SAVE MARKIEVICZ POOL & GYM

While we do not oppose the MetroLink project as a whole, and while we support the development of public transport, the proposed plan for the Tara St MetroLink station – which requires the destruction of a vital public sports amenity and 78 homes – will have a devastating impact on this inner city community and will severely impact on the sporting and recreational opportunities for all who live and work in or near Dublin city centre.

I will now detail the shortcomings in TII's responses to our observation on the MetroLink Railway Order.

Slide 3 – Tara Station Location Options

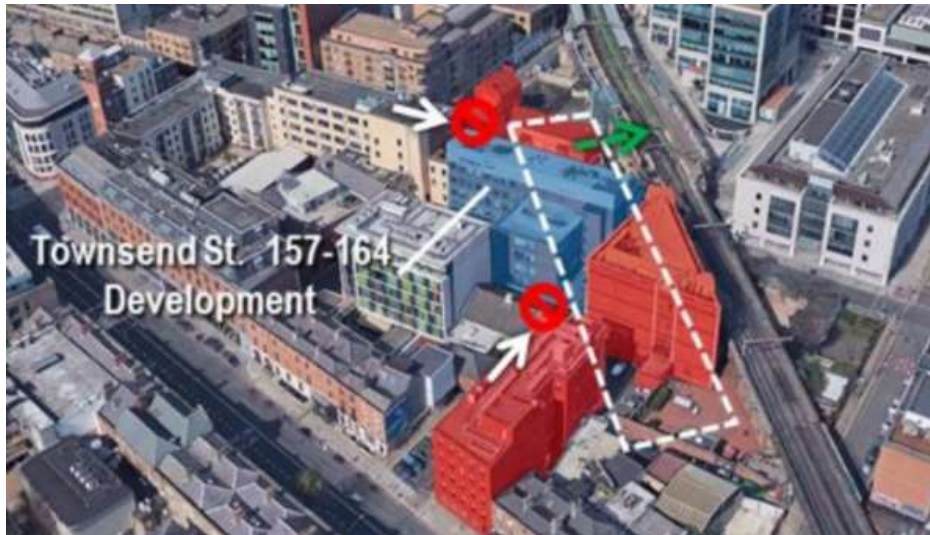
Preferred Option 0 includes effects on "a large diameter sewer" (Appendix M. Tara Street Station 2.2.1) but Option 2 was dismissed in part because it would affect "a large sewer". [Reference Jacobs Idom report 2019/02/22 - released under FOI top p 6]

Appendix M p.297 highlighted a major problem with Option 3 under heading Utilities –"Irish Water unlikely to agree diversion or interference with sewer". It seems given the size and scope of the project relatively speaking a small detail to overcome. What reason have TII to state this? Have they attempted to address this question to Irish Water and when?
